August 24, 2006

Re: Status of Improvement Permit Application #06-5-15411

On , 2006, an Environmental Health Specialist from the Harnett County Health Department attempted to evaluate your property for the purpose of issuing an Improvement Permit. This individual was unable to evaluate your property for one or more of the following reasons.

SURVEY FOR: PROPOSED PLOT PLAN - LOT - 149 WOODSHIRE S/D, PHASE FOUR		BENNETT SURVEYS, INC. 1662 CLARK RD., LILLINGTON, N.C. 27546 (910) 893-5252	
TOWNSHIP ANDERSON CREEK	COUNTY HARNETT	20' 0 40'	SURVEYED BY: FIELD BOOK

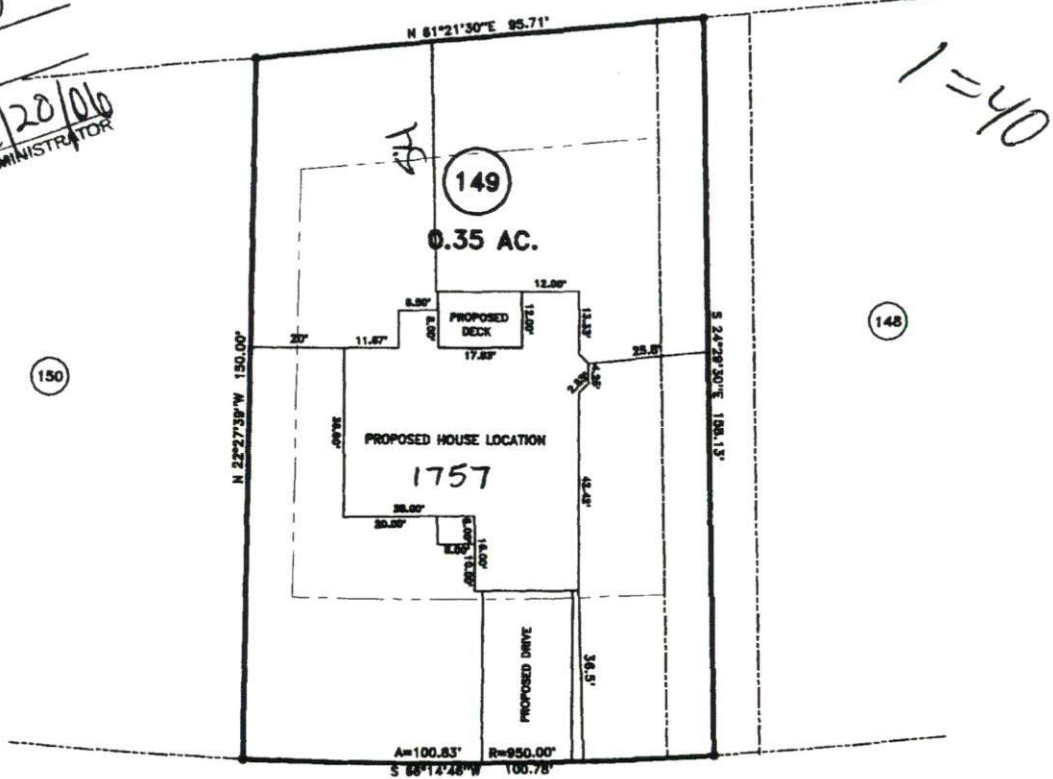
- 1. Property lines/corners not marked or labeled
- 2. House corners not marked or labeled
- 3. Directions not clear to property
- 4. Property needs brush or vegetation removed
- 5. Backhoe pits required
- 6. Other – House must be three bedrooms. Please submit changes to Central Permitting.
